WELWYN HATFIELD COUNCIL – DEVELOPMENT CONTROL
DELEGATED REPORT

| APPLICATION No: | S6/2007/543/FP |

The application seeks to demolish the existing detached chalet style bungalow with pitched roof garages and replace it with a new detached two storey dwelling with attached triple garage.

project	DORMERS, KENTISH LANE BROOKMAN'S PARK, HERTS.	date	03/07	scale	1:100	drawn by	me
drawing	PROPOSED GROUND FLOOR PLAN	drwg. no	ELP - 02	rev

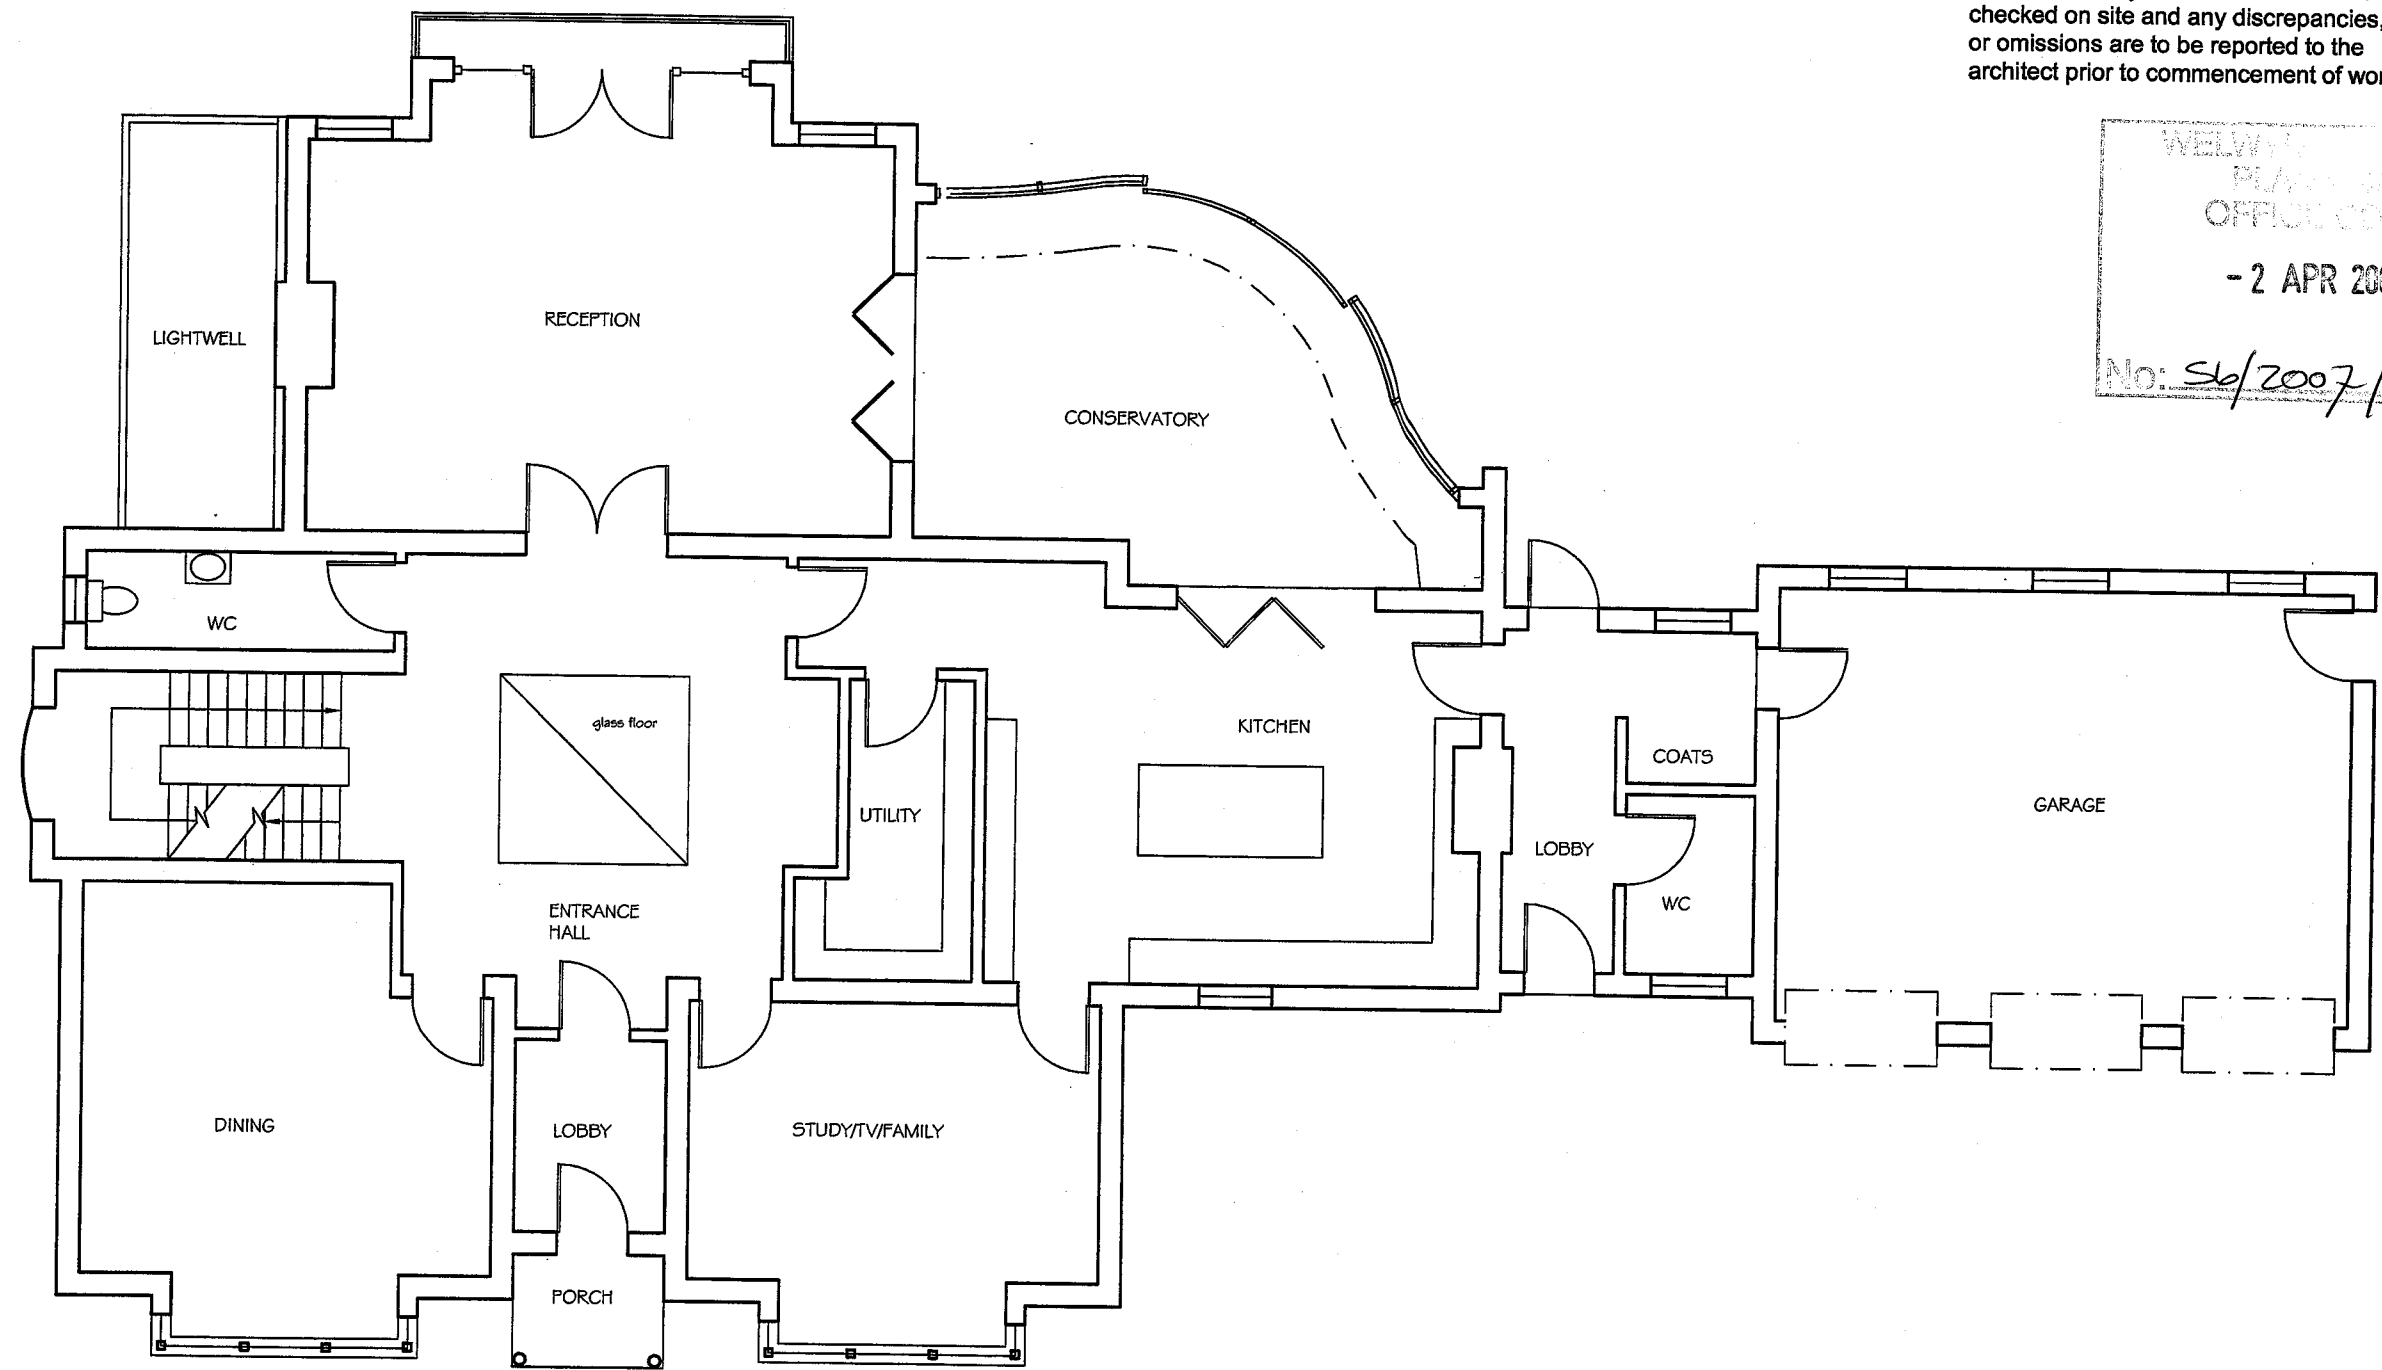
The Council's assessment of existing gross floorspace is different to that of the agent in regards to the existing dwelling (266.27 compared with 388 sq.m). There are also differences in the proposed floorspace with 580.7 sq.m compared to 542 sq.m. It is not clear why there are these differences; however this could partly be accounted for within the Council's calculation, which was based on previous site

However, taking into account the differences in these figures, even if the more favourable ones are considered, there is no question that the proposal at 40% would far exceed the size of the original dwelling and as such this is considered to be materially larger than the existing dwelling (see Green Belt table below).
